Please ask for: Ms Iqraa Malik
Email: iqraa.malik@terraquest.co.uk
Telephone: 01212341390
Our Ref: BE/144/20/HH
Your Ref:
Date: 10th December 2020

Application for Planning Permission for Works or Extension to a Dwelling

Development: Retrospective planning application for attached single storey garage with storage area
Location: 1 Markfield Bersted PO22 9HW

Title
EXISTING AND PROPOSED FIRST FLOOR
PLAN AND GARAGE ROOF PLAN - NO CHANGE

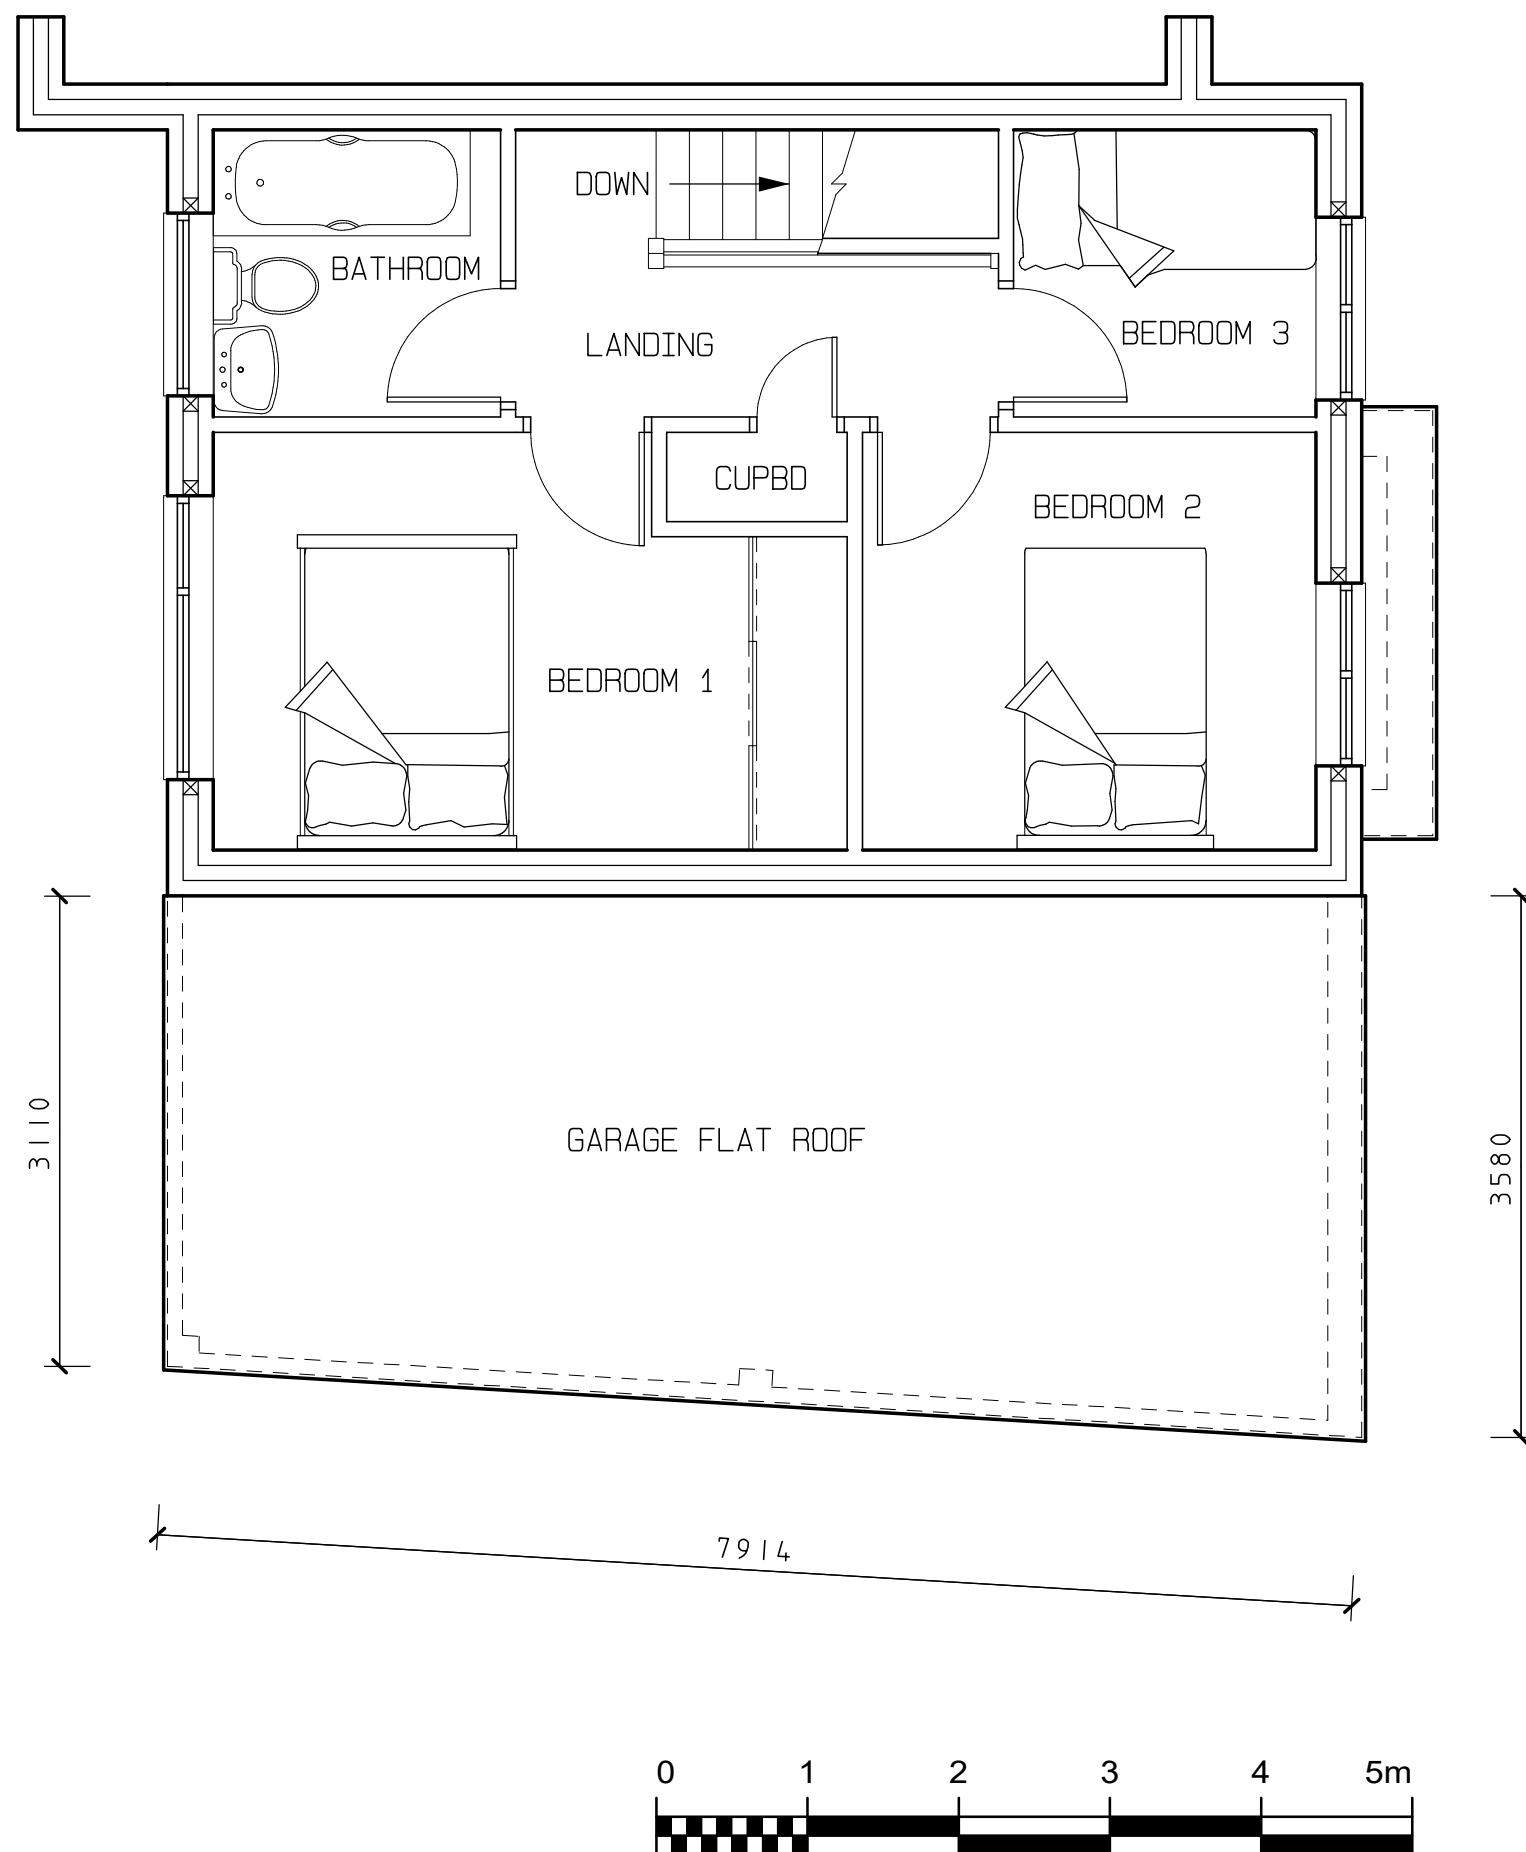
Room Labels: You are required to include room labels on all plans.

Title
ORIGINAL AND CURRENT SITE PLANS
PLUS BLOCK PLAN

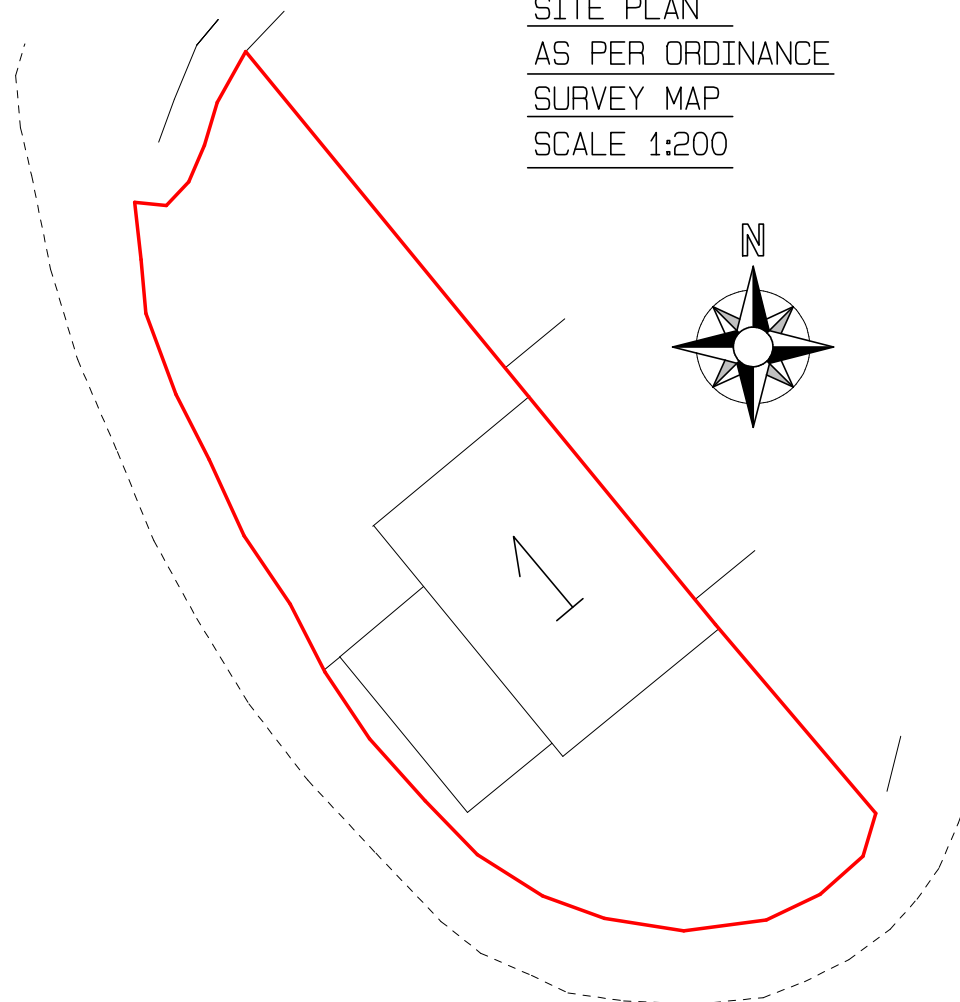
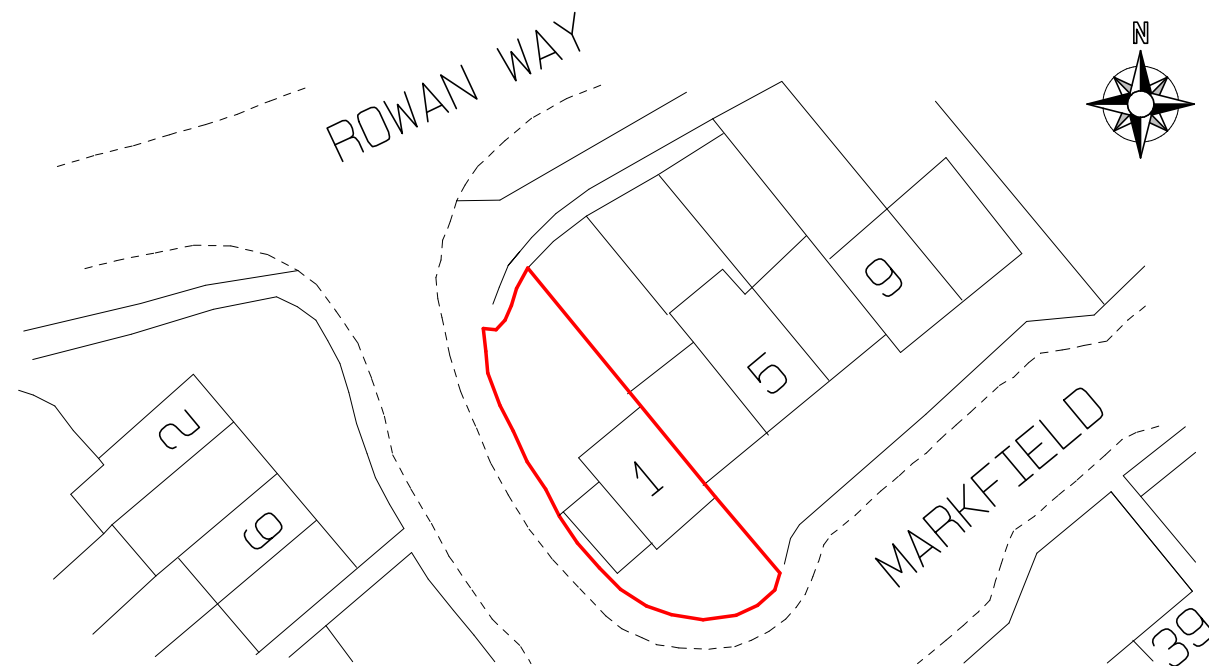
Dimensions: You are required to include dimensions from the proposed extensions to all site boundaries. Please amend
